Our ref: NO/2013/105329/02-L01
Your ref: 3/2013/0535
Date: 28 August 2013

**THE ERECTION OF A SINGLE COTTAGE (ALTERNATIVE SCHEME TO PLANNING
PERMISSION 3/2011/0618) - REVISED PLANS
LAND ADJACENT 10 THE DENE, HURST GREEN, CLITHEROE**

4378 -02C

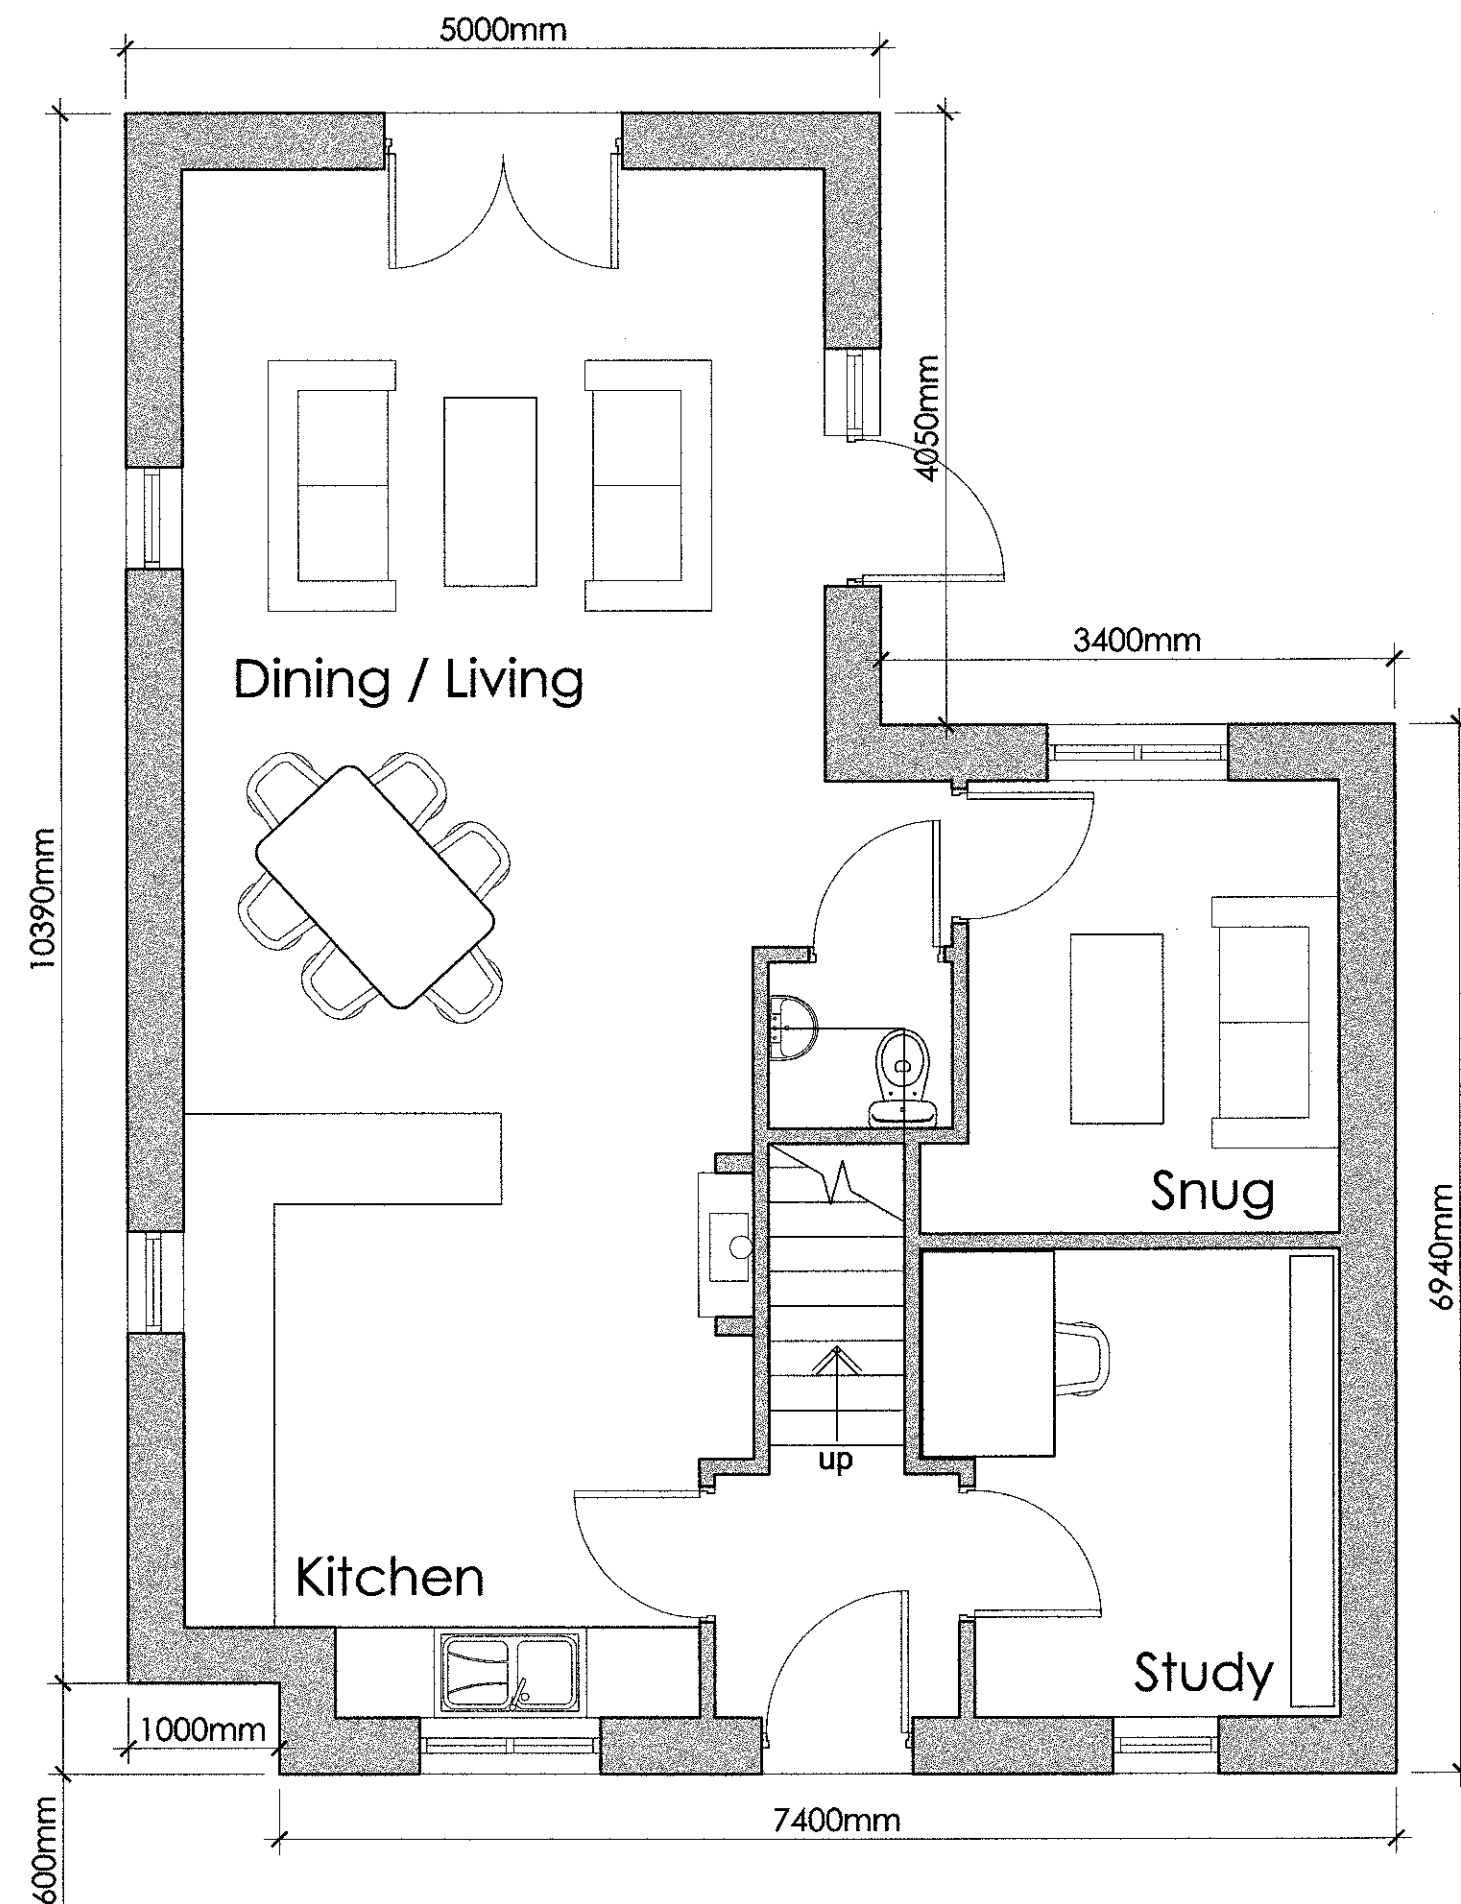
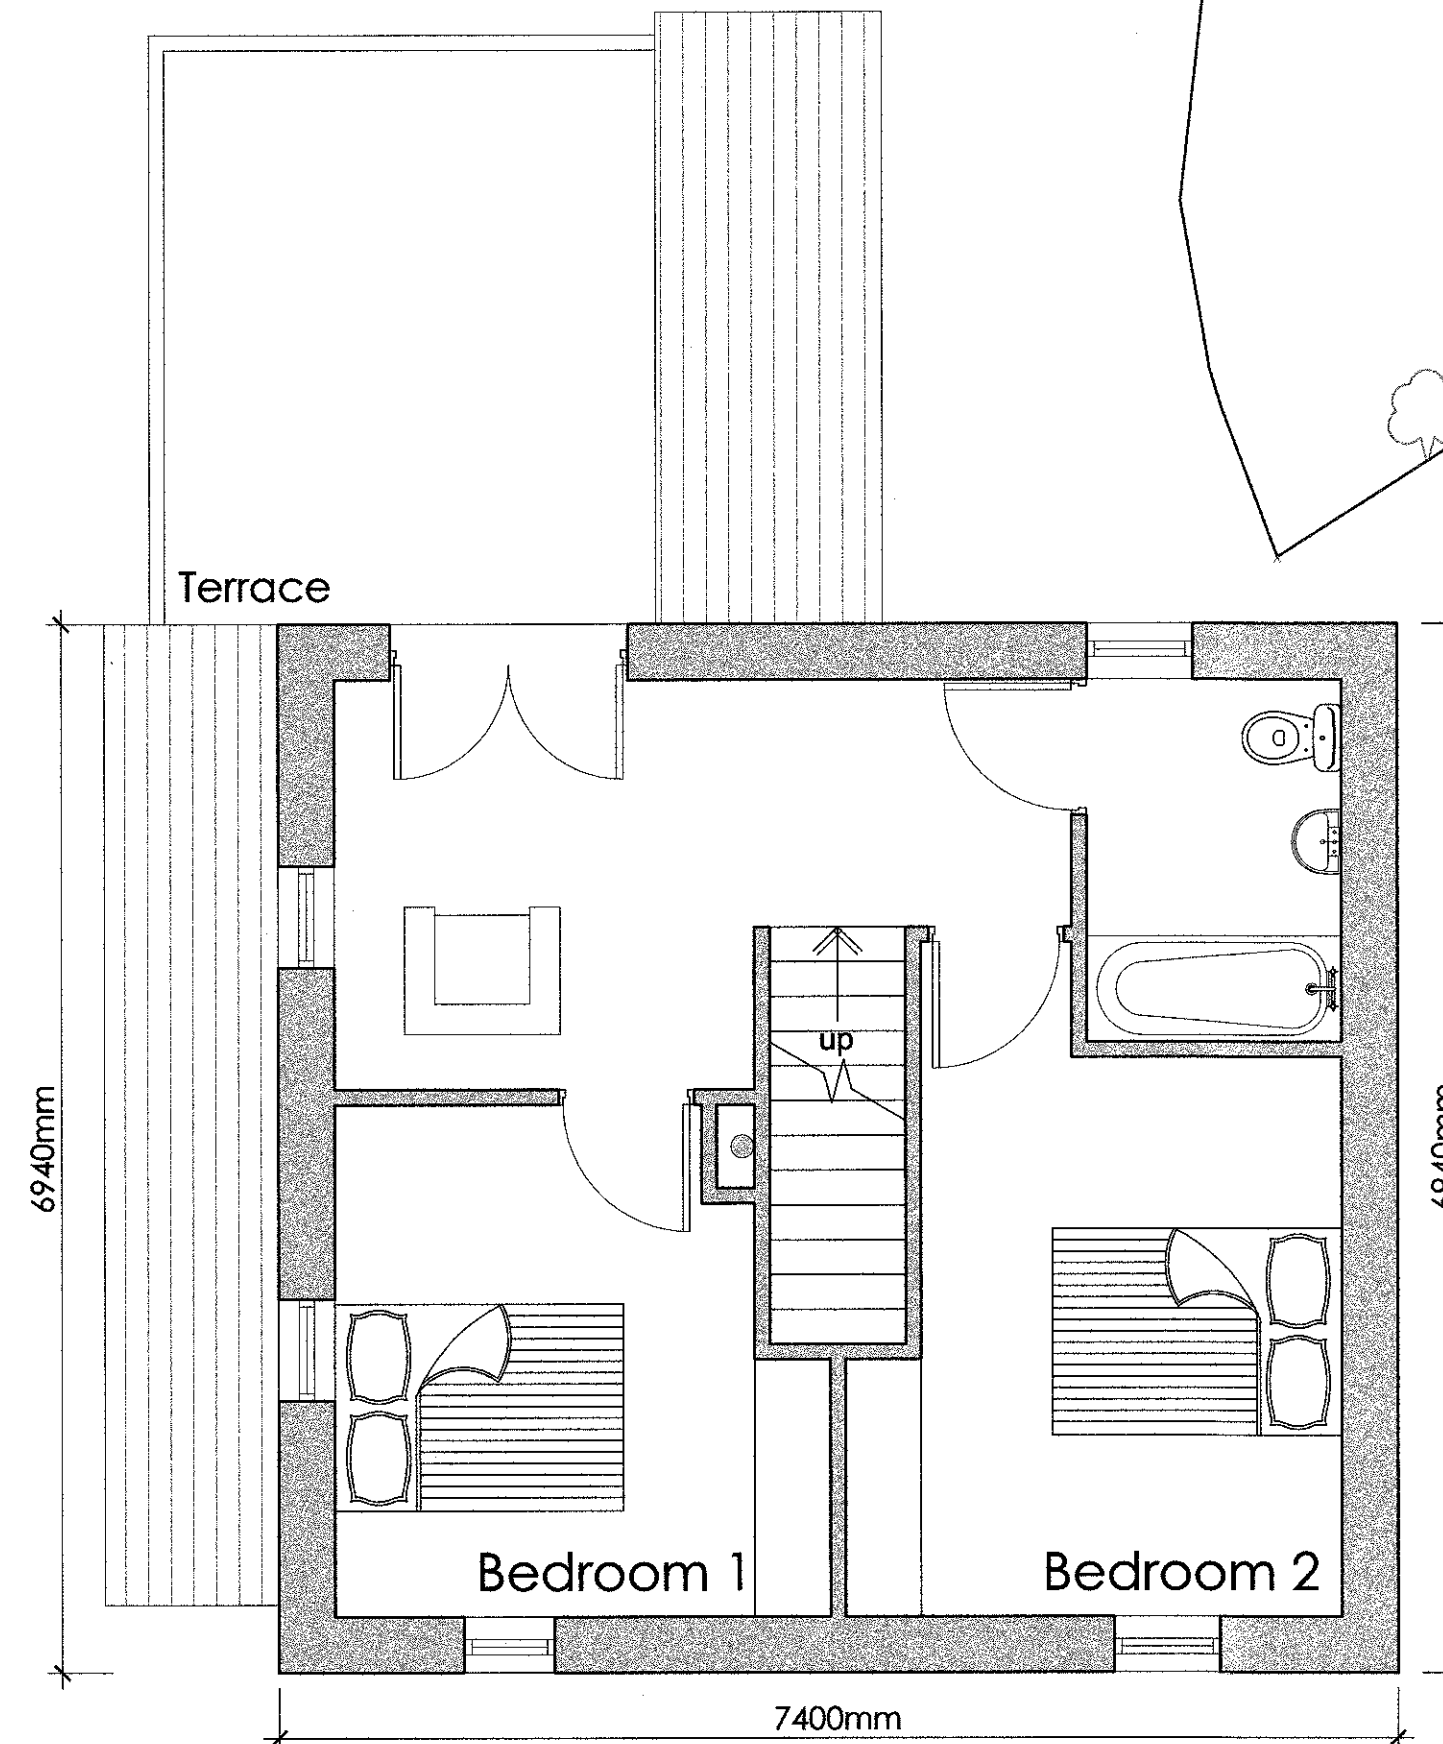
Having regard to the proposed amendments as identified in drawing number 4378-02C, the proposed layout has been revised such that all bedrooms are at first floor level and the ground floor is to accommodate the proposed kitchen, dining and living areas.

The proposed amendments will ensure that future occupants will be at no greater risk of flooding and we **withdraw our objection** to the proposed development.

The proposed development should proceed in accordance with the mitigation measures outlined in the Flood Risk Assessment submitted with the application to ensure the risk of flooding to the property is managed appropriately.
